From: June Grinstead [REDACTED]
Sent: 12 November 2018 10:48
To: Zac Denton
Subject: Re: 67 Norfolk Road

The applicant has confirmed that she is going to plant bamboo along the fence to replace the Holly Tree and Shed, which grows higher than the fence. Would you like me to add this to the block plan?

Block Plan

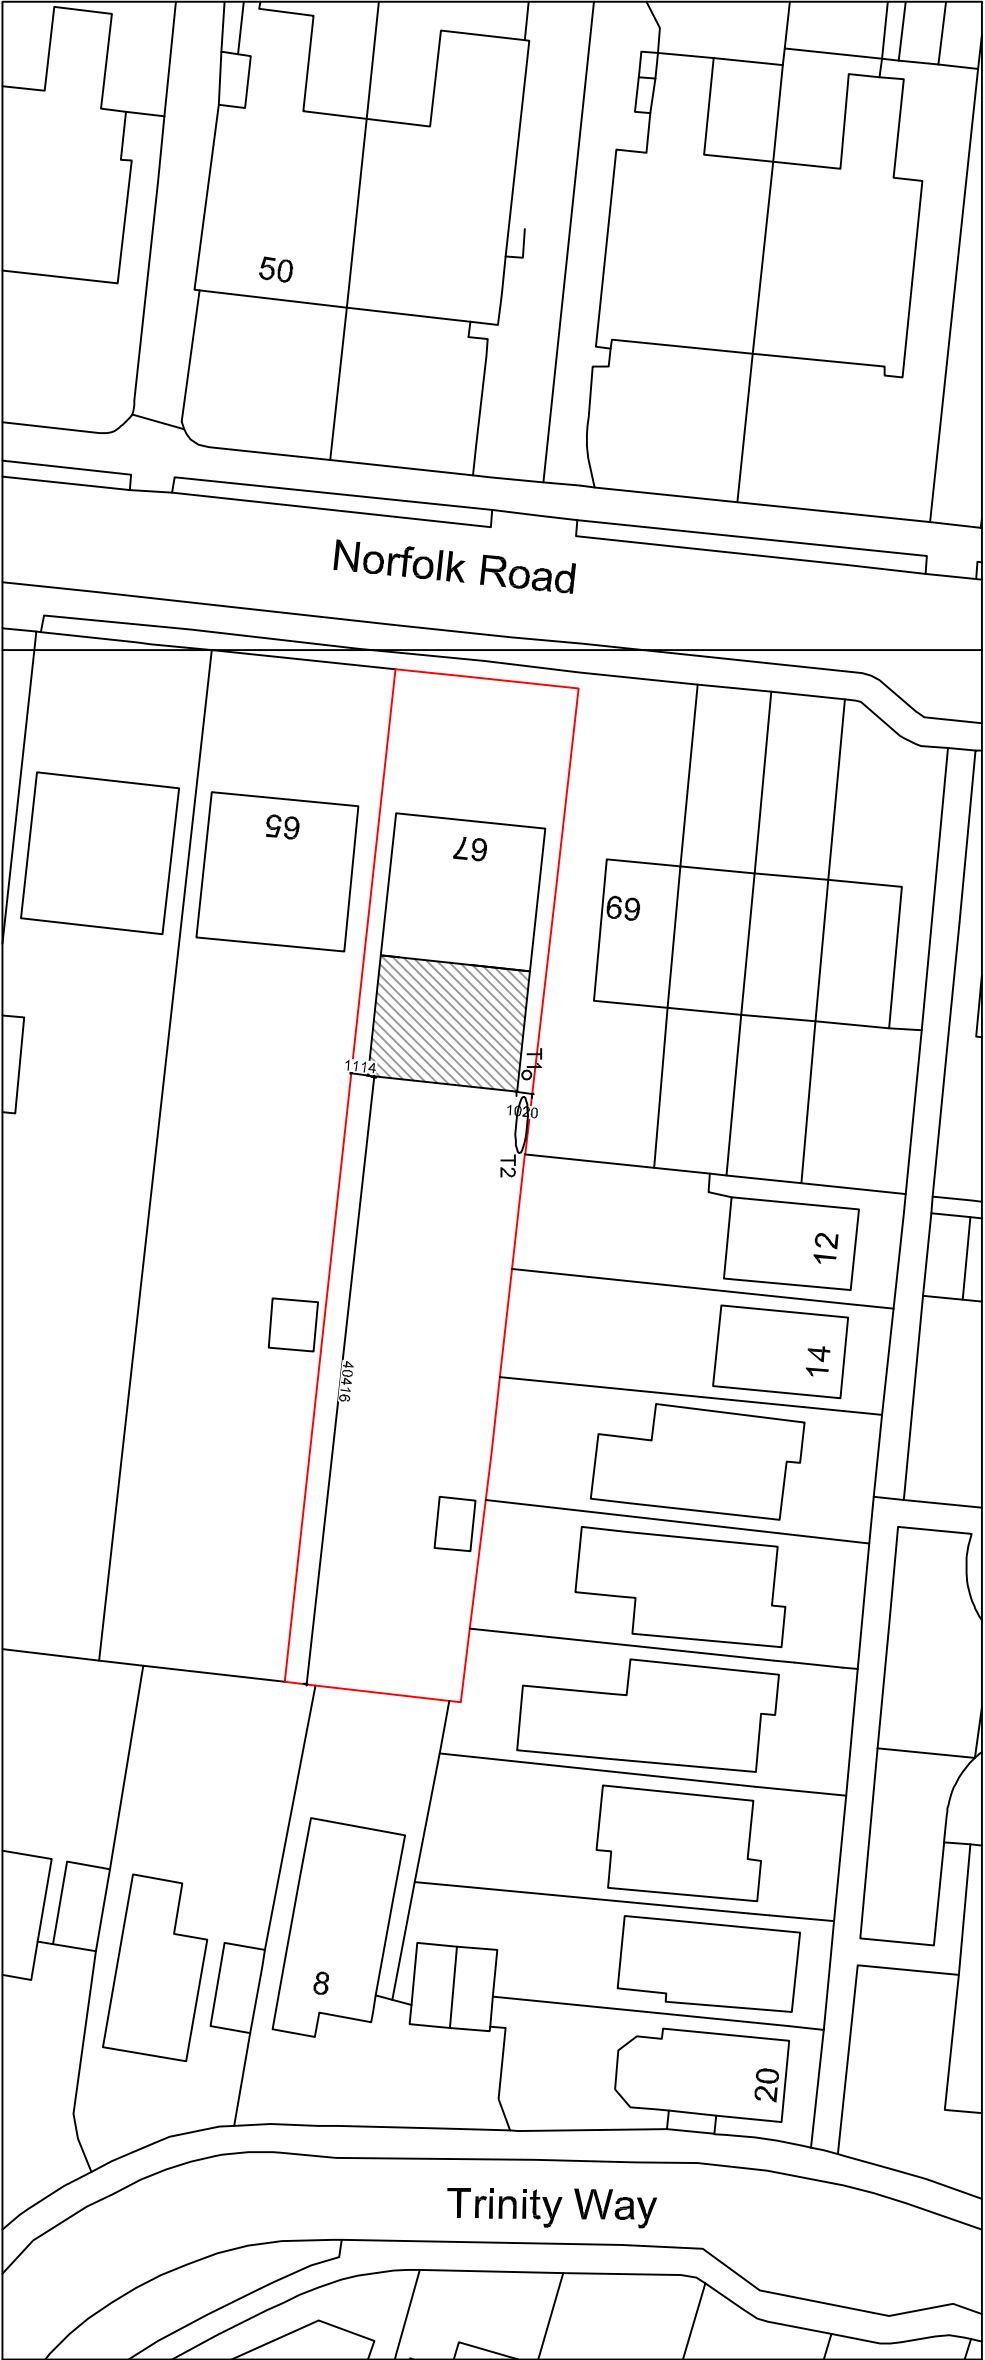
I very much appreciated your call this morning. Please find attached the revised Block Plan as requested. If there is anything else I can do please let me know.
